16 December 2021

**Prestons Waste Treatment Facility
State Significant Development SSD-9346594 (SSD Application)**

16 December 2021

SSD-9346594 – PRESTONS WASTE MANAGEMENT FACILITY SUBMISSION

DRAWING TITLE:
MECHANICAL SERVICES
STAGE 1 - WASTE TREATMENT FACILITY
GROUND LEVEL VENTILATION LAYOUT
9 WHYALLA PL

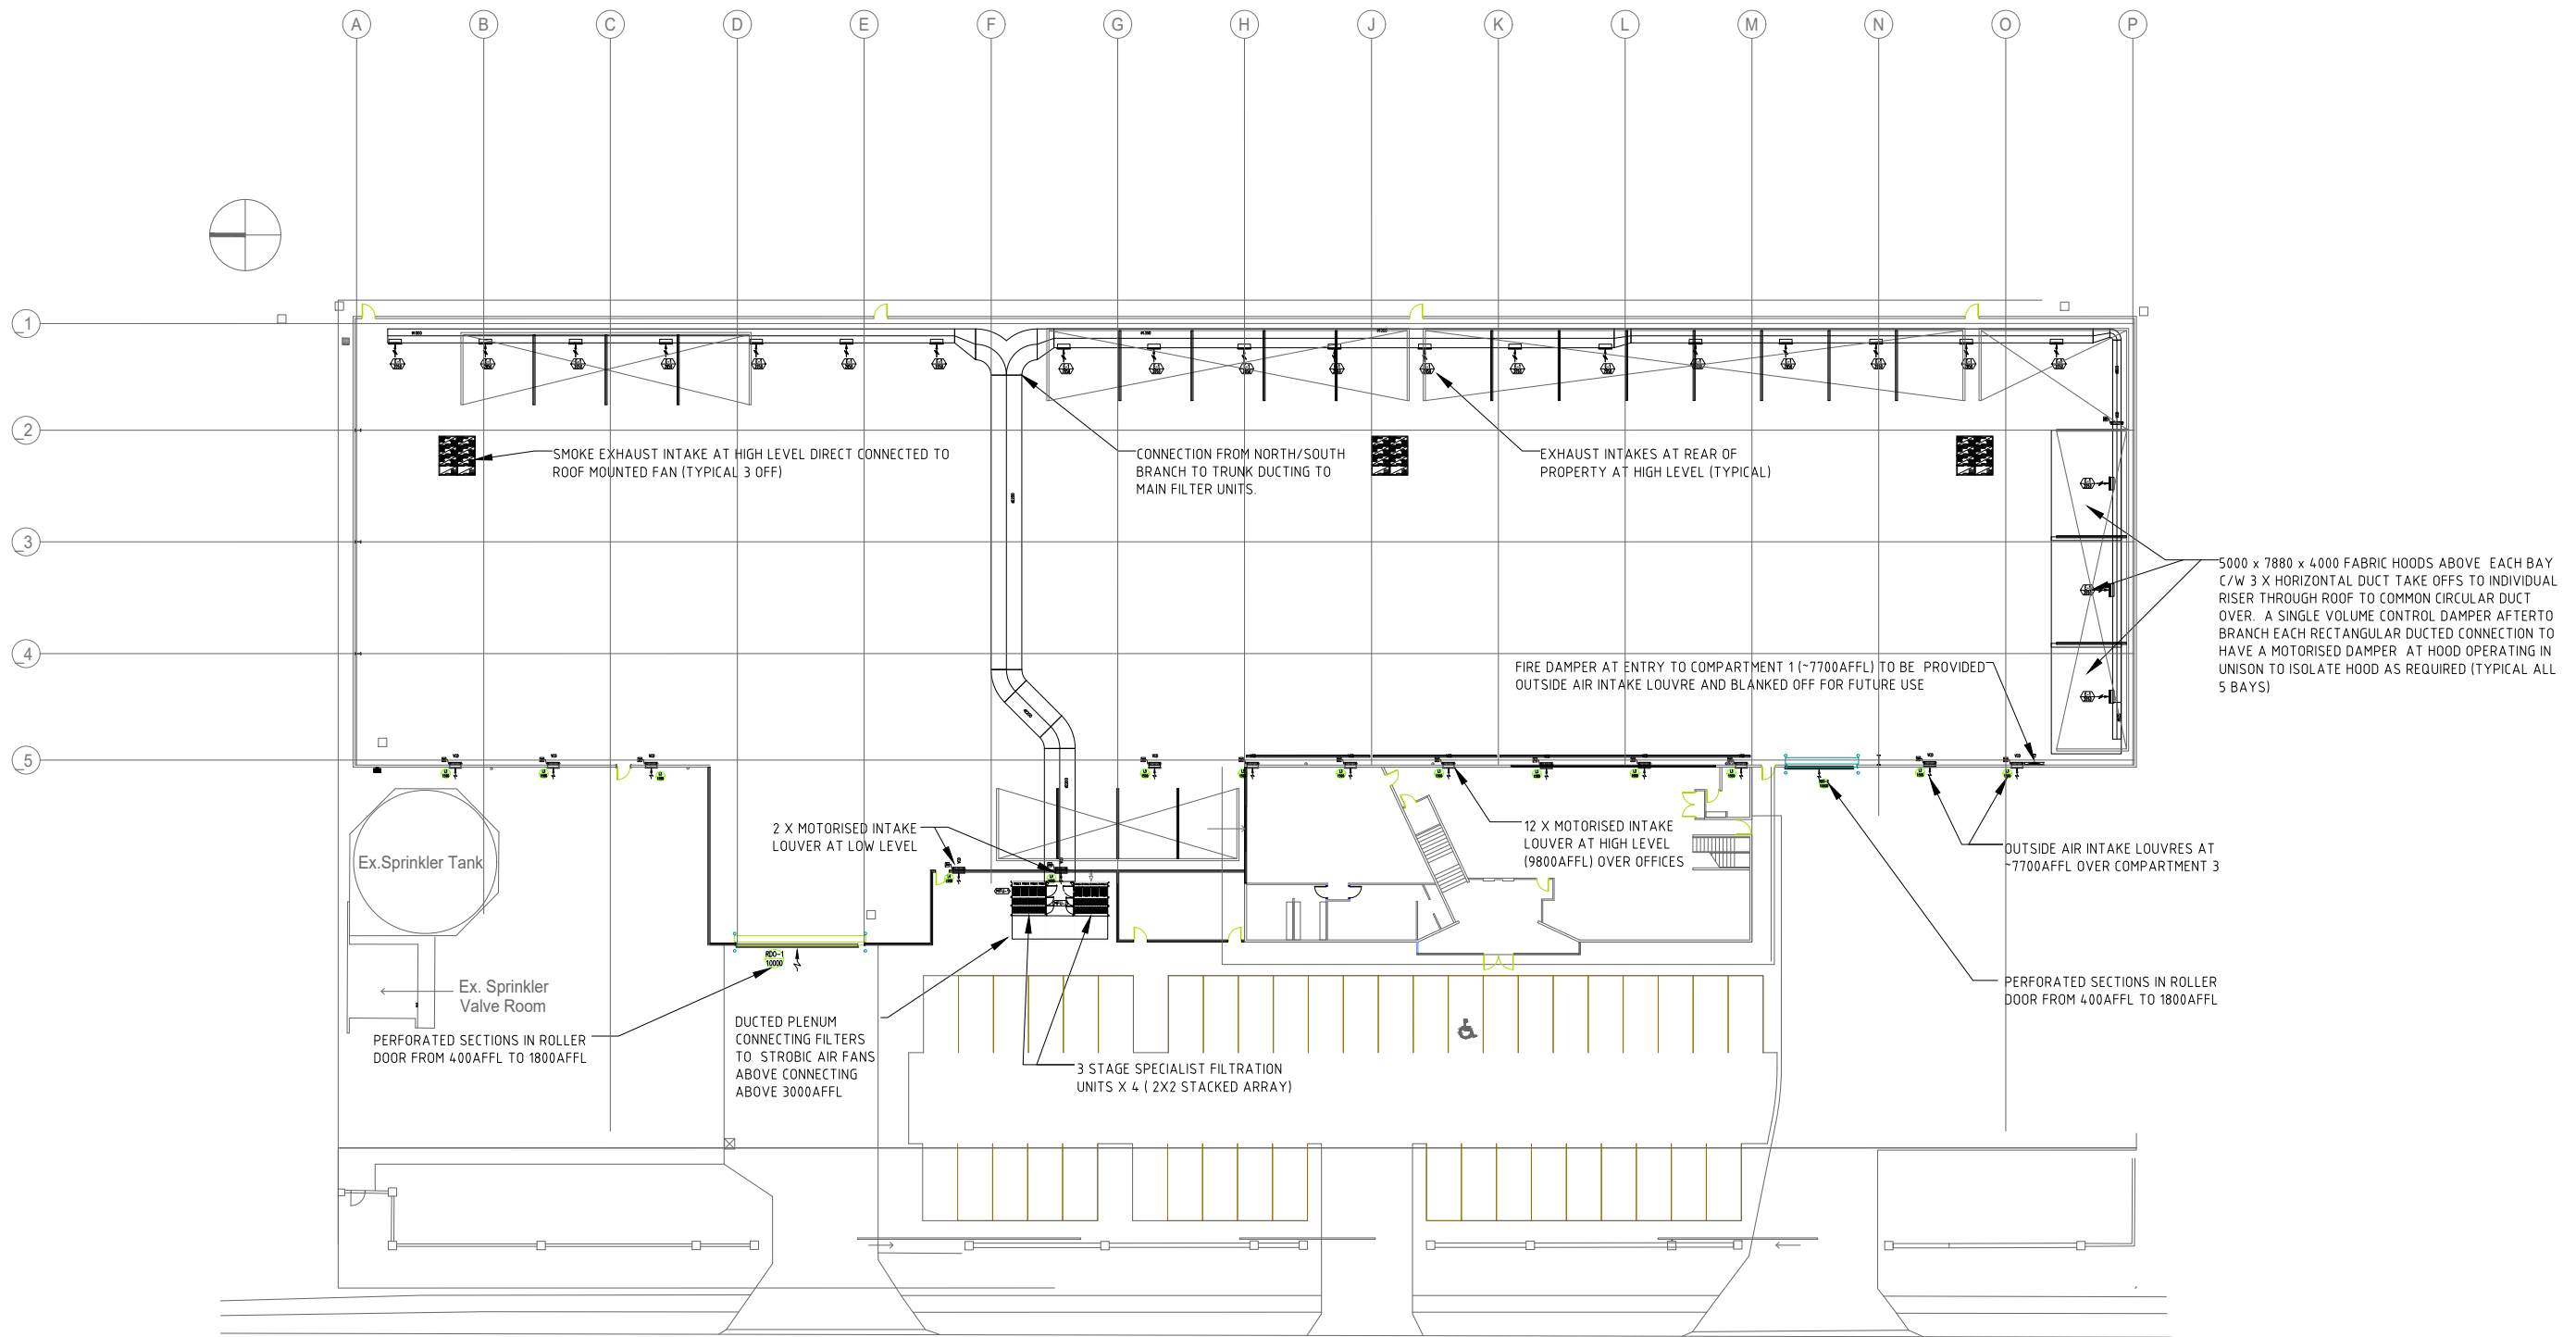
One of the key air quality safeguards nominated on Page 164 of the Main EIS is high-speed roller-doors that will be required to be closed during loading/unloading and handling of wastes. Also building compartments will be maintained at a negative pressure of more than -5 Pascals to avoid fugitive emissions. However, it is noted in the traffic report on Page 150 of the Main EIS that 26 truck movements will occur during a peak hour either entering or leaving the facility. If it were assumed that it could take about one minute to open a door, drive a truck through and close the door, this means that a door could be partially or fully open almost half the time during a peak hour. It is not clear how negative internal pressure will be consistently maintained during this period.
